**CITY OF ALBUQUERQUE
PLANNING DEPARTMENT
June 11, 2014
DRB Comments**

PROJECT # 1009243

APPLICATION # 14-70192

RE: Lots 3-9, Block 5, Mesa Grande Addition

PLAT OF
 LOTS 3-A AND 9-A
 BLOCK 5

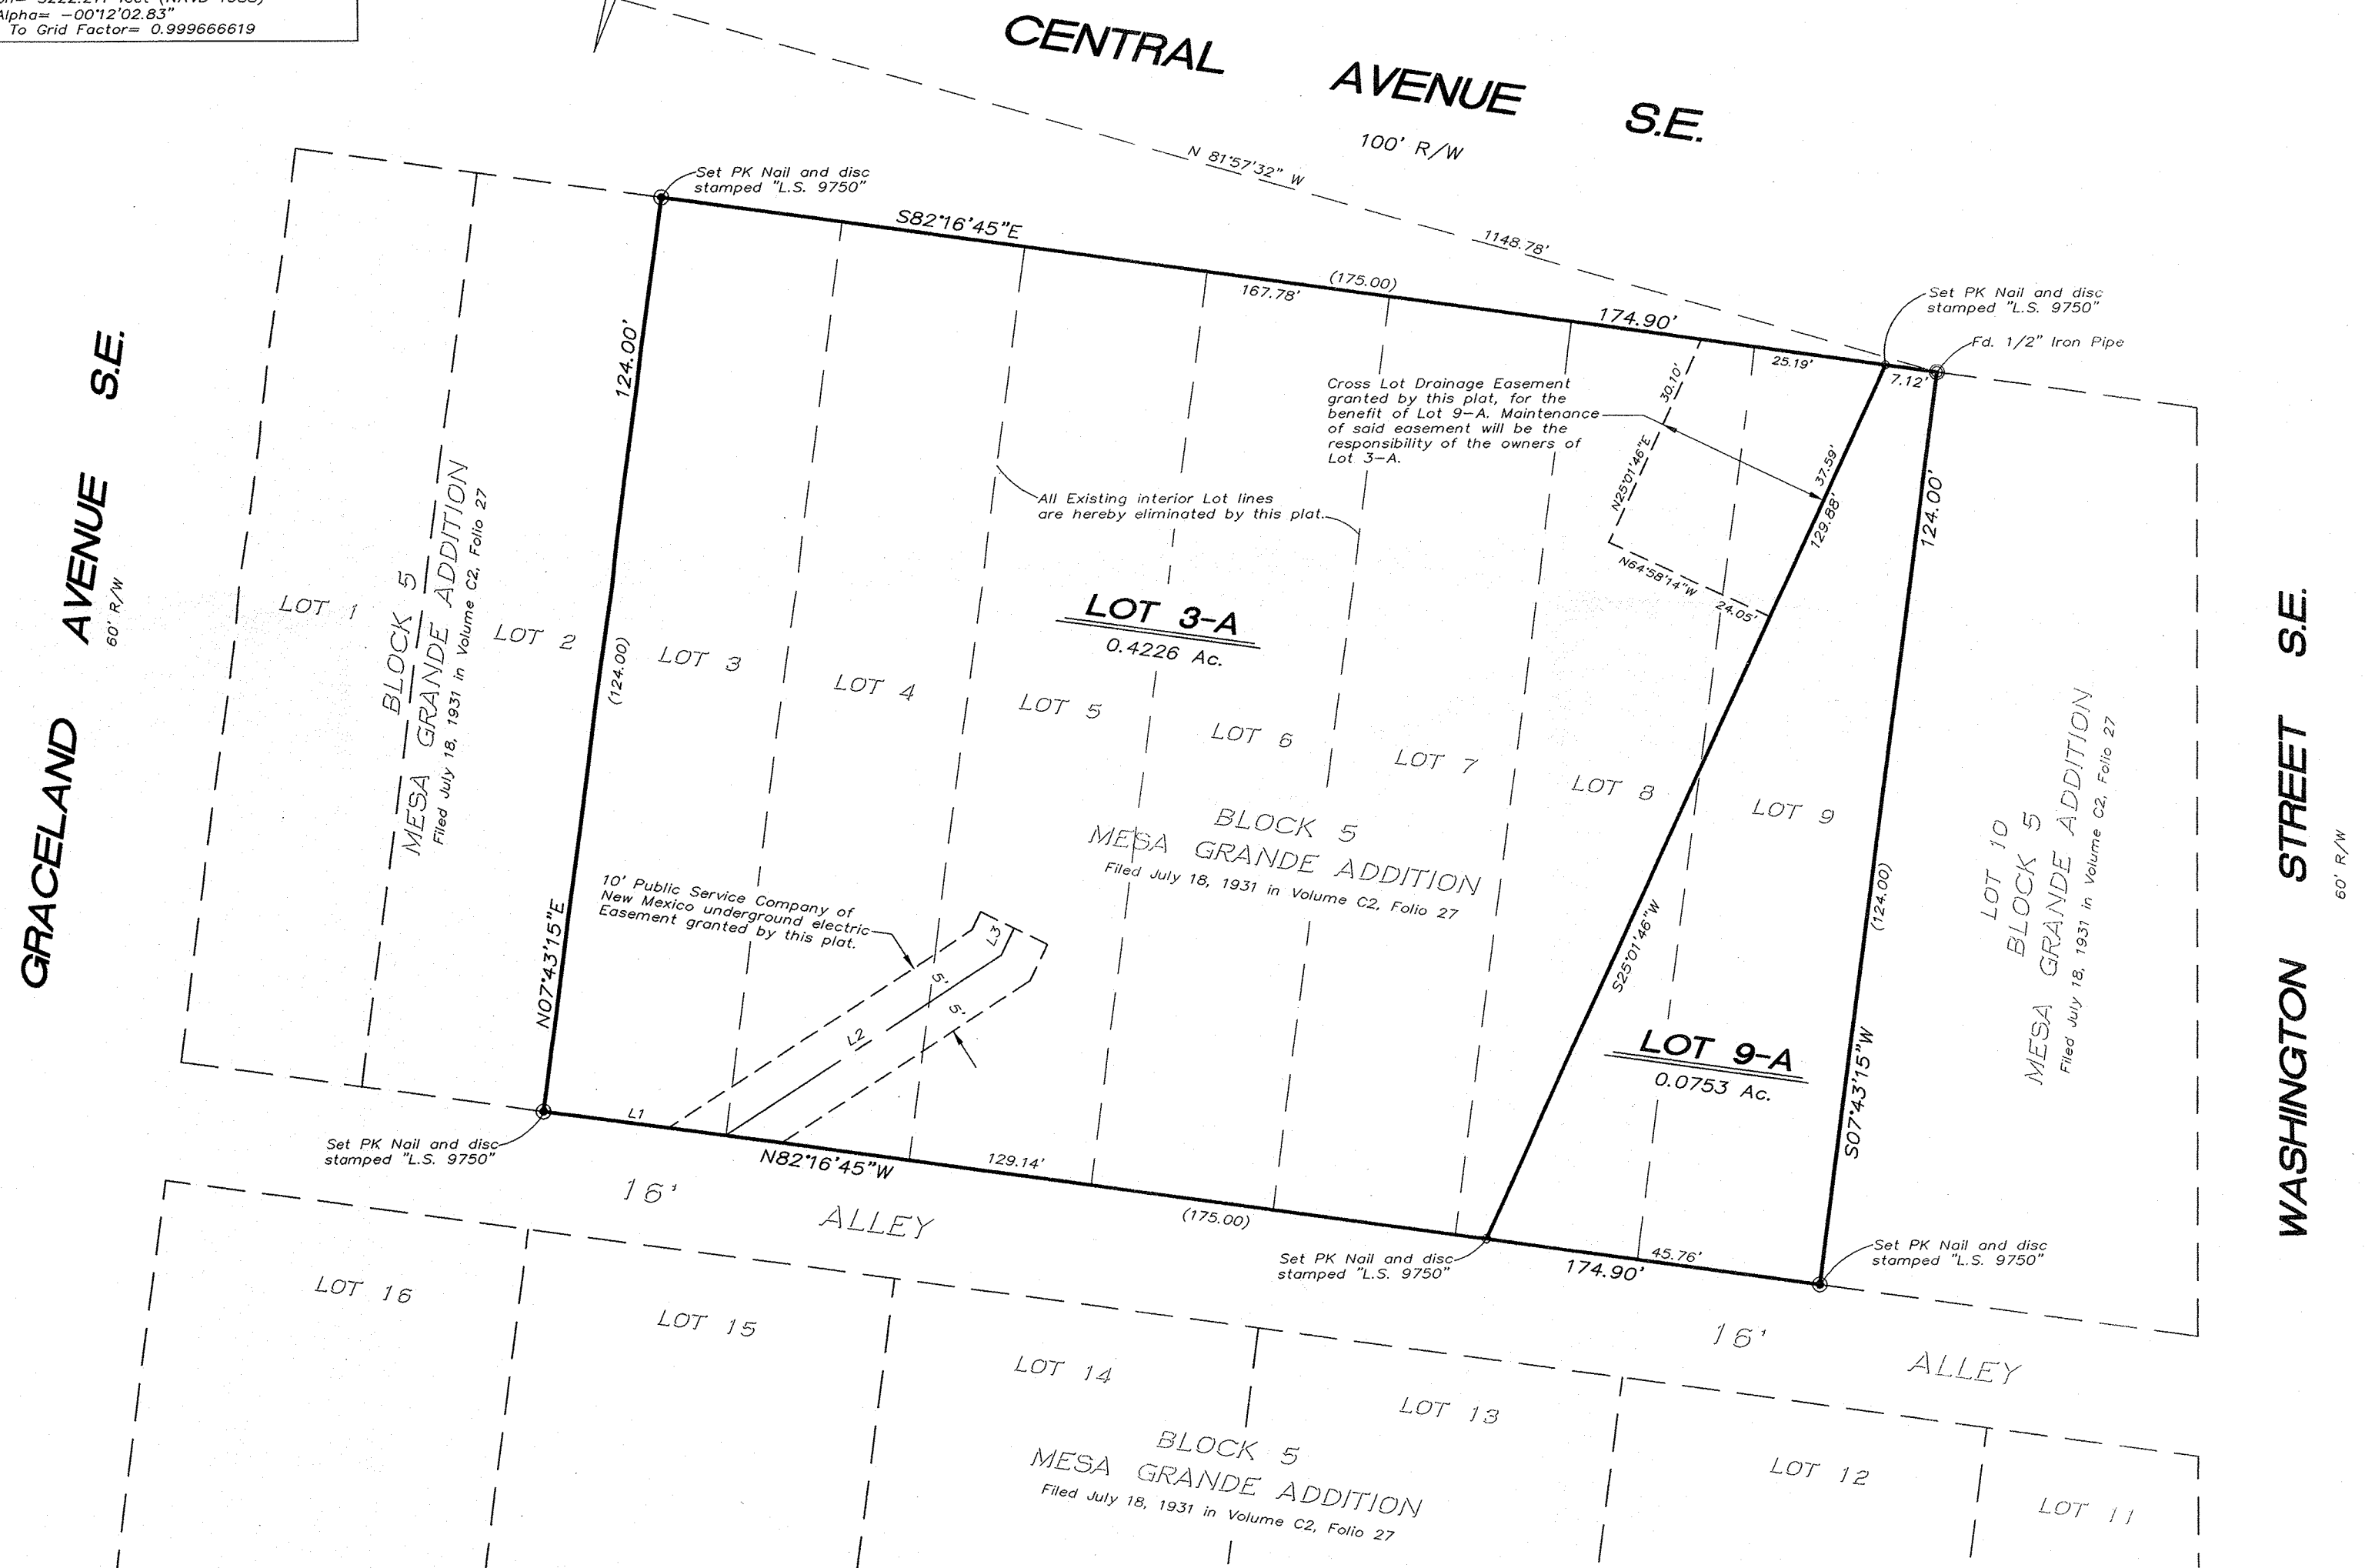
An architect's or engineer's certification of compliance with the Building Code for common walls on proposed property line is required, to demonstrate compliance with the Purpose and Intent of the Subdivision Ordinance. This may require retrofitting any entry/wall openings between the two proposed lots. An access easement is needed unless an alternate alley entrance is constructed for the building on proposed Lot 9-A.

An architect's or engineer's certification of compliance with the Building Code for common walls on proposed property line will be required, which may include retrofitting any wall openings between the two proposed lots. Reciprocal access/ drainage easement will also be needed.

ABCWUA Comment: Each property will be required to have a separate water and sewer service account.
